## City of Albuquerque Stormwater Construction Site Inspection Report

Project Name and Location	<u>check-fil -A</u>		
	<u>Yale and Gibson</u>		
	<u>Tour Park</u>		
Site Contact Name & Agency	<u>R &amp; O construction</u>	Contact Phone #	<u>801</u> <u>391-5638</u>
Date of Inspection	<u>1-4-16</u>	Start/End Time	<u>12:00/</u>
Inspector Name, COA Dept.	<u>Curtis Cherne, Stormwater Quality</u>		
Inspector Phone / E-mail	<u>505-924-3420/ccherne@cabq.gov</u>		
Inspector Qualifications	<u>Qualified Compliance Inspector of Stormwater- Stormwater One</u>		
Describe Present Phase of Construction	<u>Stabilizer</u>

**From:** Cherne, Curtis  
**Sent:** Friday, August 07, 2015 12:53 PM  
**To:** jairp@randoco.com; Josh Skarsgard  
**Subject:** SWPPP inspectio chick-fil-a  
**Attachments:** concrete-washout.jpg

**From:** Cherne, Curtis  
**Sent:** Wednesday, July 29, 2015 2:33 PM  
**To:** 'jairp@randoco.com'; 'tylerc@randoco.com'  
**Cc:** 'josh@skargardfirm.com'  
**Subject:** SWPPP inspection Chick-fil-A 1600 University Tracking number NMR12B852, NMR12B551  
**Attachments:** entrance.jpg; sediment-university.jpg; sediment-university2.jpg; silt-fence.jpg; trash.jpg; trash-pile.jpg

CWA-1. CONCRETE WASHOUT AREA

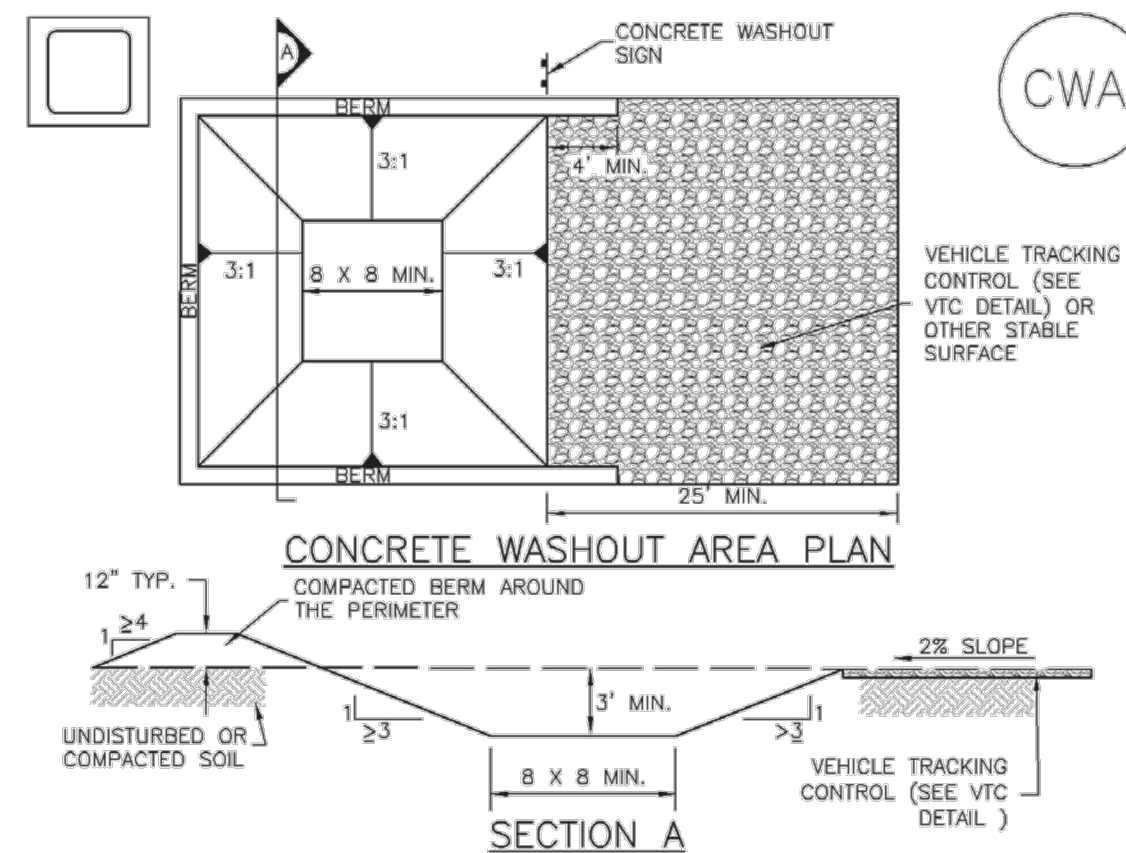
- Entrance / Off Tracking new entrance - no track-out
- Sediment Controls / Silt Fence, Check Dams, Waddles, etc. good
- Erosion Controls / Mulch, Seed, no
- Wind Blown Erosion no
- Housekeeping / Pollutant Controls concrete washout in NPZ canal  
still some trash but way better
- no concrete washout station

Jair,  
Thanks for taking the time to speak with me today.  
I like the new construction entrance and the site had considerably less trash. Thanks. However, there was some in the southeast corner.  
Things were going pretty good until I came across the concrete wash-out.

Per our discussion you will remove it within seven days.

Stabilized Construction Entrance/Exit

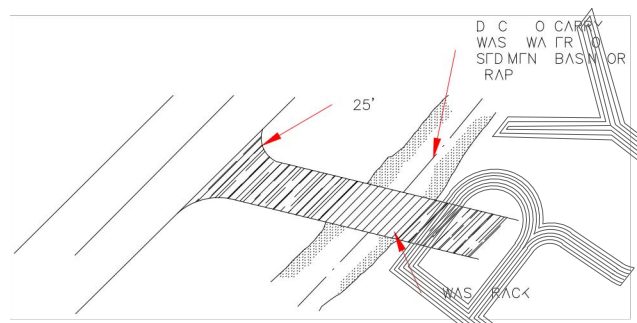
1. Lots of trash all over the place.
2. The construction entrance was full of sediment and did not appear to have filter cloth underneath it. It's a redo.
